Comments on Aviation Assessment submitted with Planning Application 19/02708/OUT

Bicester Gliding Centre has carefully reviewed outline planning application 19/02708/OUT and the associated aviation assessment. Please see our initial response for further information on Bicester Gliding Centre. Several subject matter experts have provided input for the following comments.

F.A.S.T. Indicative Layout Plan

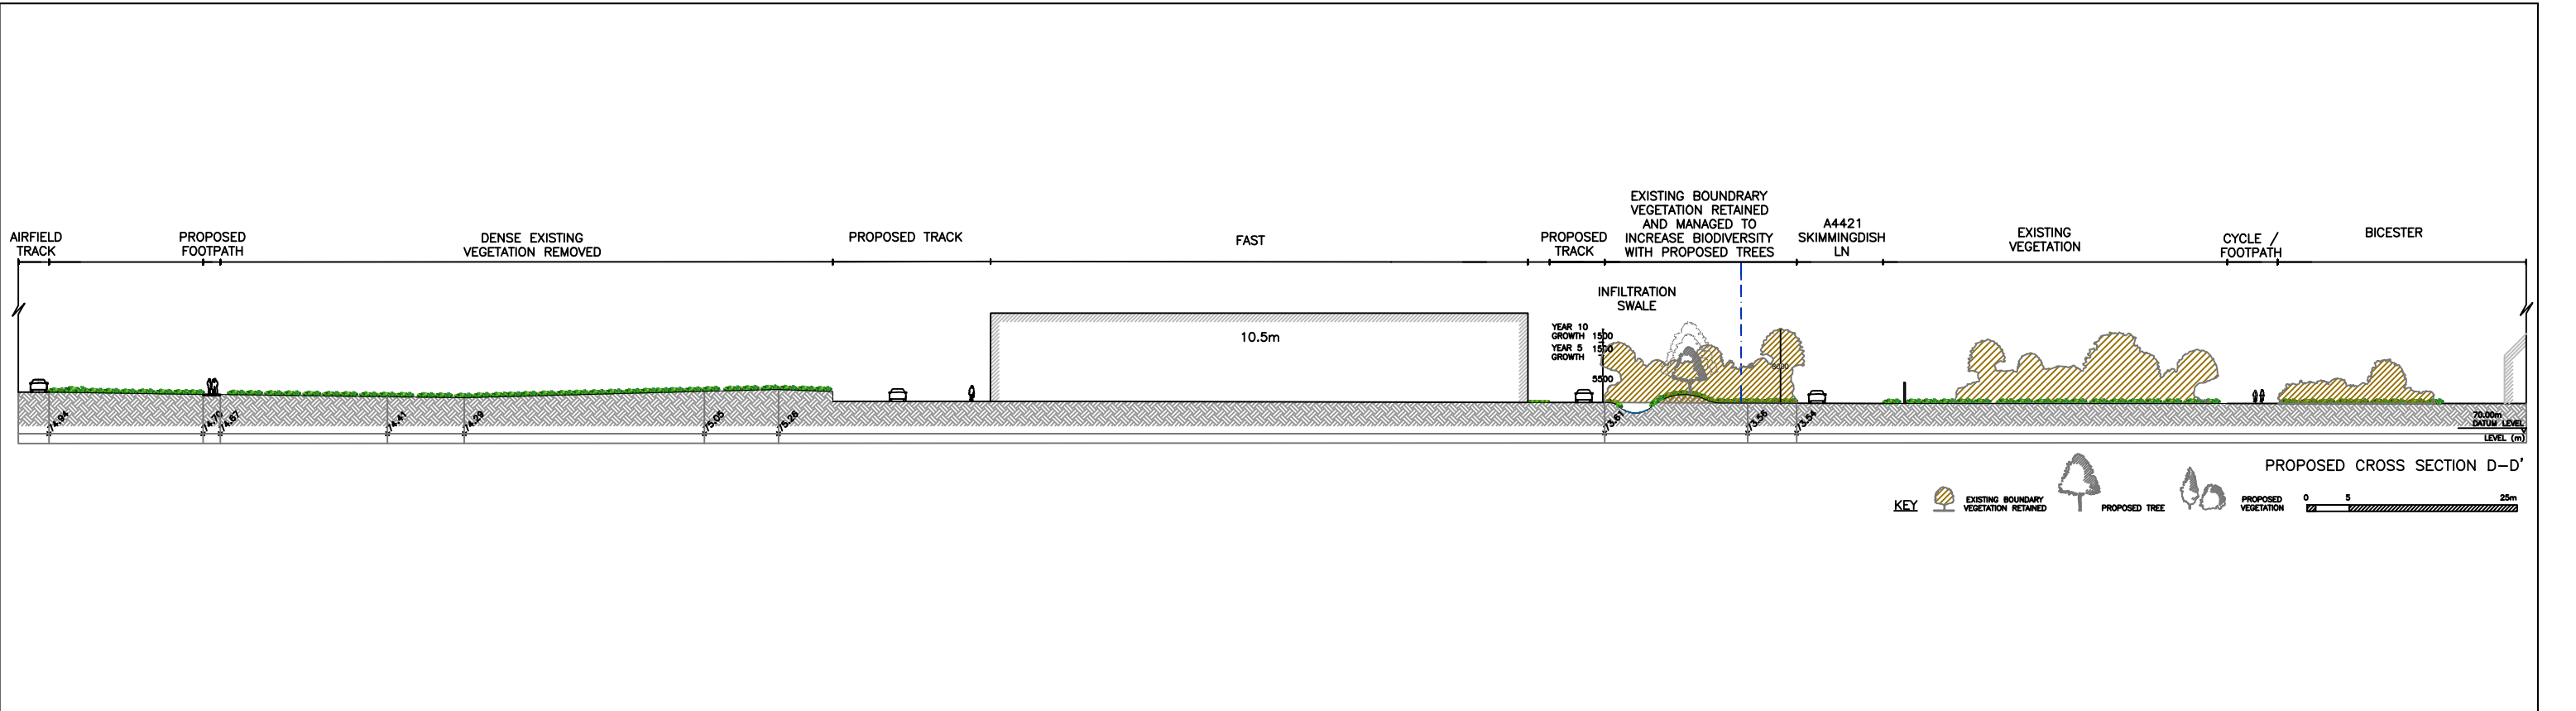
We note that the analysis has misplaced the position of the southern end of run 18/36. This may be because although the run was historically designated 18/36, over time it has become 17/35, as can be observed on Google Earth. The southern end of the run is approximately 100m to the east of the position shown in figure 6.1 of the assessment and is thus more affected by the highest of the F.A.S.T. buildings than allowed for. This will impact on the type of vintage aircraft that might fly at Bicester in future but should have little impact on glider operations. The runs 18 and 36 (or 17 and 35!) are the most used for aero-tow launching with 52% of launches and 48% of days. If the height of the F.A.S.T. buildings was to be reduced to that necessary for their intended use, the impact on run 18/36 would be minimised. The drawing in Paragraph 4, Part 3 of the design and access statement shows a building that is far higher than required for a vehicle workshop.
